Re: Railway (Metrolink - Estuary to Charlemont via Dublin Airport) Order [2022]
Metrolink. Estuary through Swords, Dublin Airport, Ballymun, Glasnevin and City Centre to
Charlemont, Co. Dublin

Re. Application by Transport Infrastructure Ireland (TII) to An Bord Pleanála for the Railway (MetroLink Estuary to Charlemont via Dublin Airport) Order 2022.

2. Albert College Park: Intervention Shaft- Protection and Preservation of the Park and Scale of Design Footprint.

ALBERT COLLEGE PARK INTERVENTION SHAFT. PLAN
SCALE 1:400

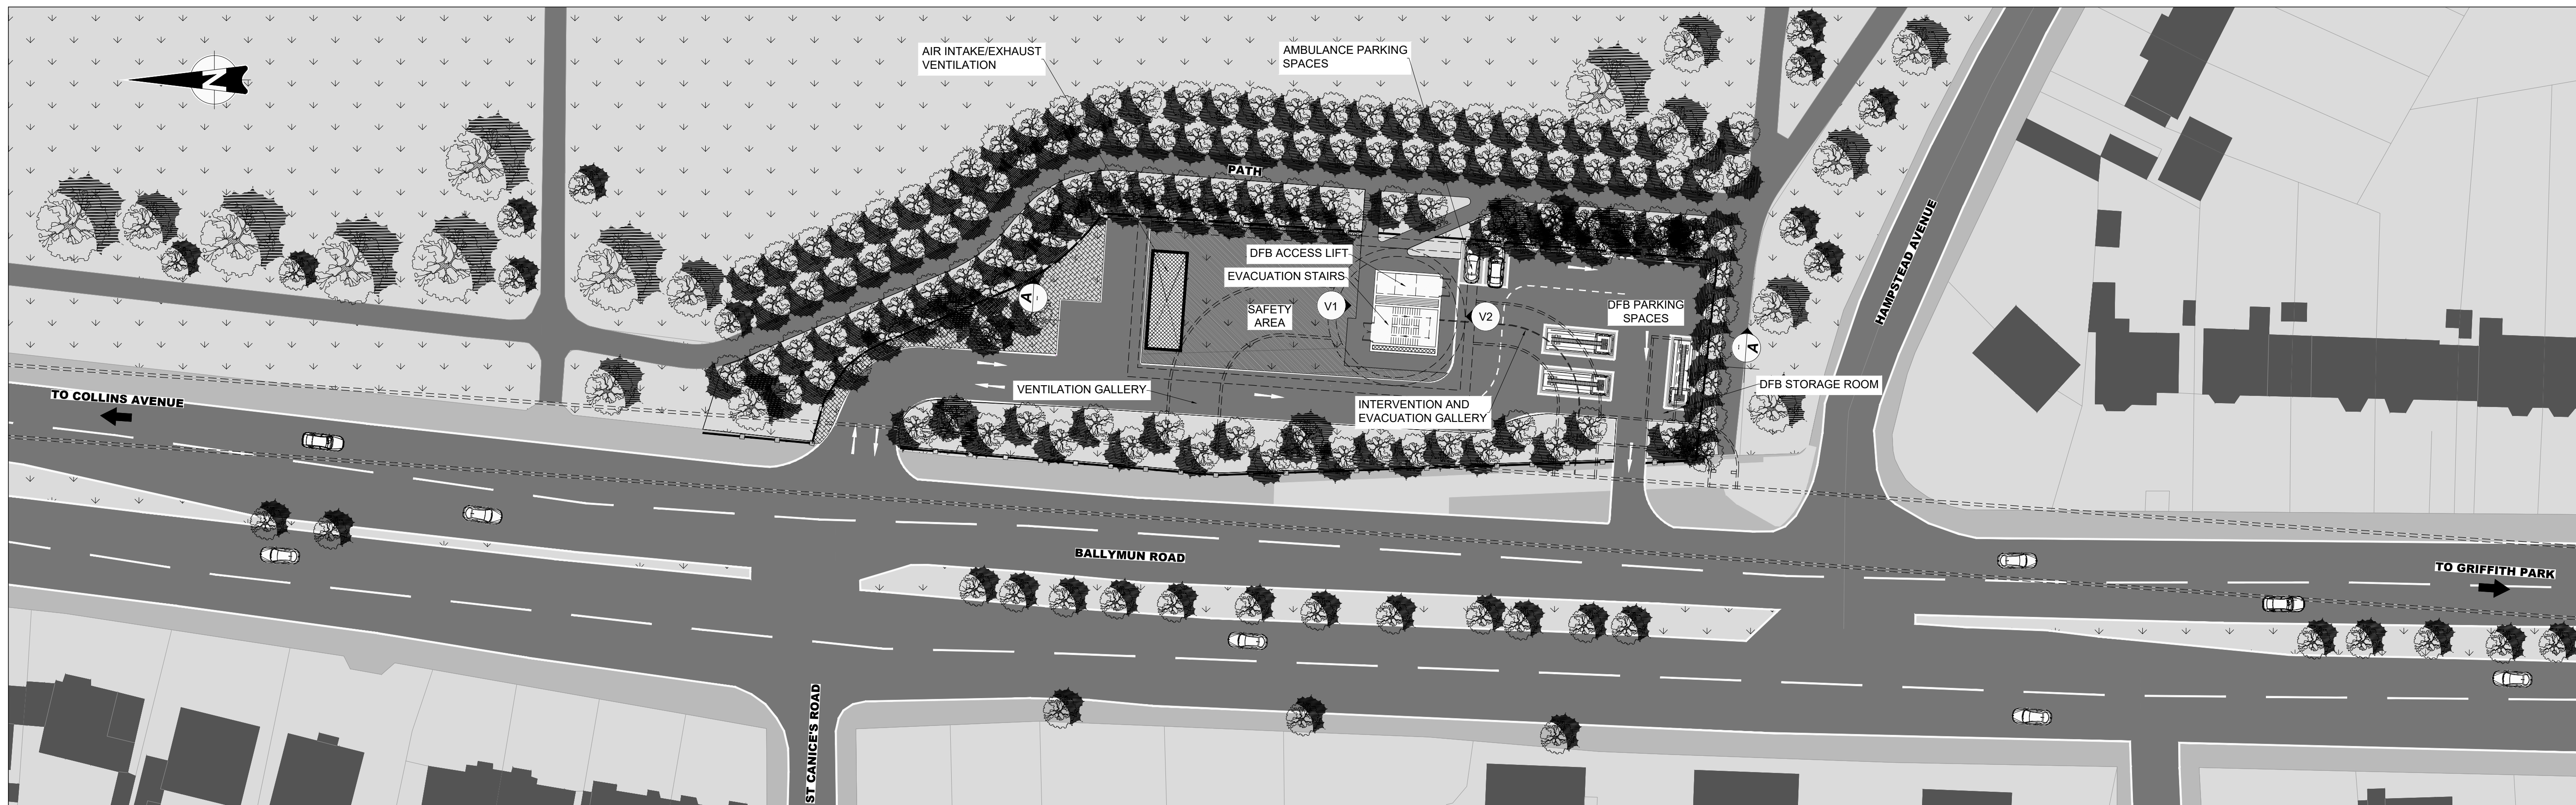
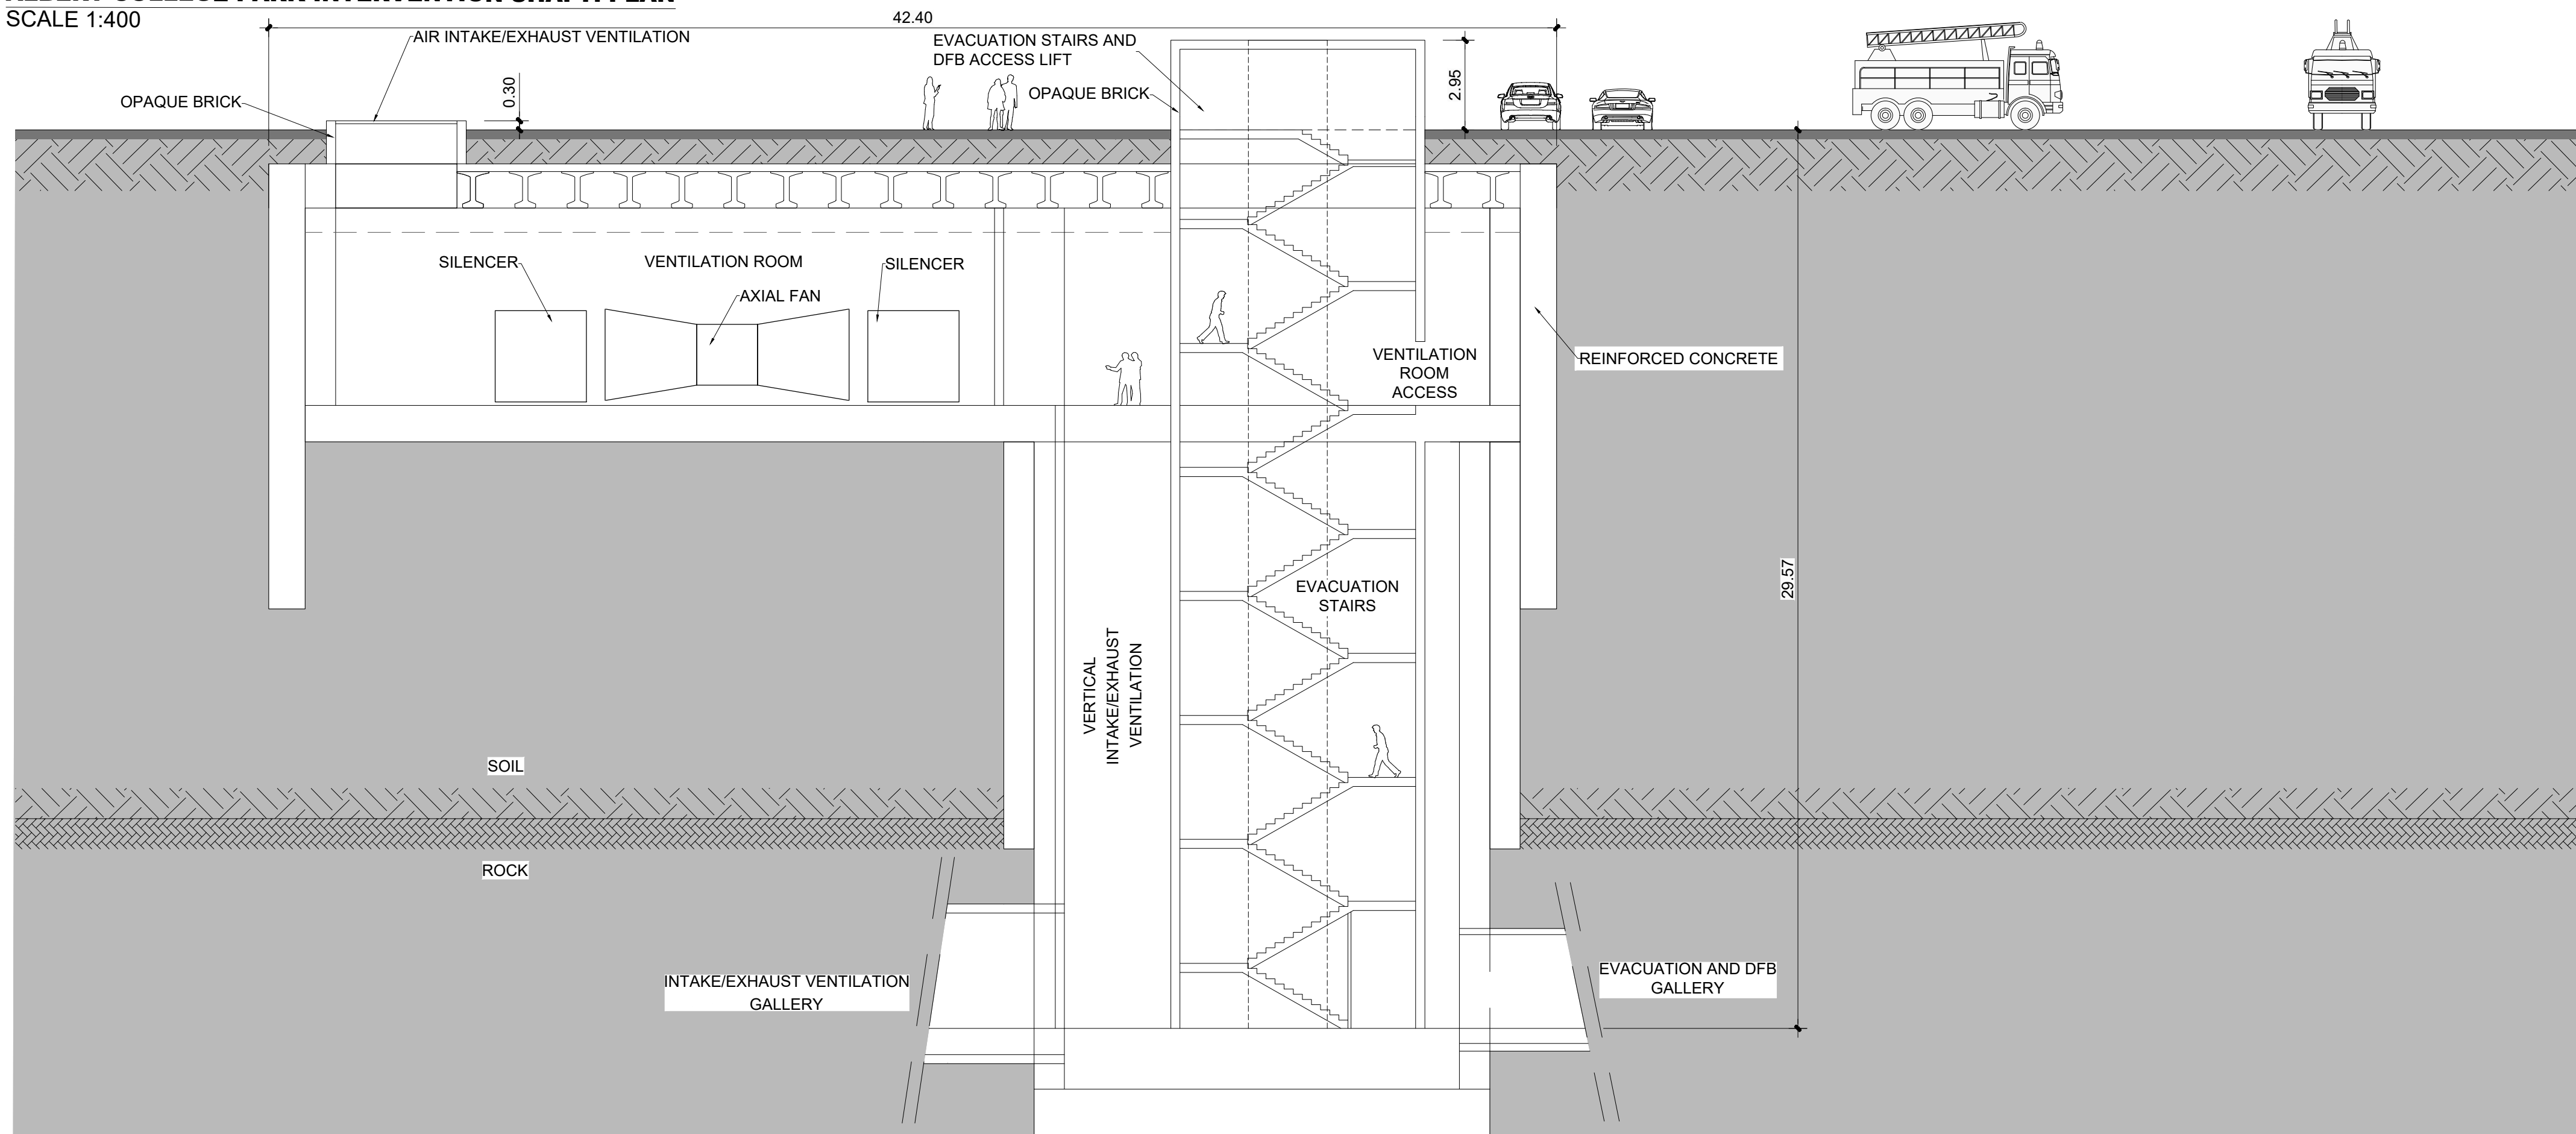
In our view the size and scale of the design of the IS proposed in ACP will negatively impact not only the visual but the general amenity of the park by reducing the area of the park that is available for walking, and sports etc.

3. We would therefore ask that an alternative to the current IS design, that would reduce its overall footprint, be fully considered. From some preliminary discussions with experts we understand that a suitable and effective IS could possibly be devised which would reduce its footprint using the kind of approach employed in the London Underground e.g. the new Elizabeth Line and Italian underground systems (see the red and yellow markings on the extract from the TII drawing of the IS **attached**-which illustrates in broad outline what the redesign and considerably reduced footprint of the IS might involve). Key issues to be considered here are:

- reducing the number of parking places and placing the ones that remain onto a grass verge at the edge of the Ballymun Road as a new emergency vehicle only layby,
- moving the Air Intake/Exhaust Ventilation structure to the main building structure for the stairs and lift: while it would make that building a little larger it would significantly reduce the 'technical footprint' of the site overall (as long as the equipment rooms below ground as currently designed remain as is and perhaps are grassed over).

Another issue to be examined in terms of reducing the footprint of the IS might be to limit it to a shaft head and the subsurface buildings with a clear paved road from the revised IS to the main road in a straight line. That would omit the parking area in particular(and having both an access and an exit road).This would be done on the basis of the Ballymun Road being closed in the event of an emergency, which we understand would be a recognised approach successfully used in the London Underground system.

4. While these are technical matters which would require detailed expert consideration we have seen no convincing analysis and rationale from TII for the proposed scale of the IS footprint in the ACP. We would ask that An Bord Pleanala as a preliminary matter in advance of the finalisation of the Railway Order require TII to give further consideration, in consultation with other relevant bodies, with a view to reducing the design of the IS in the ACP to the minimum necessary for a suitable and effective IS in order to better protect the amenity of the ACP.
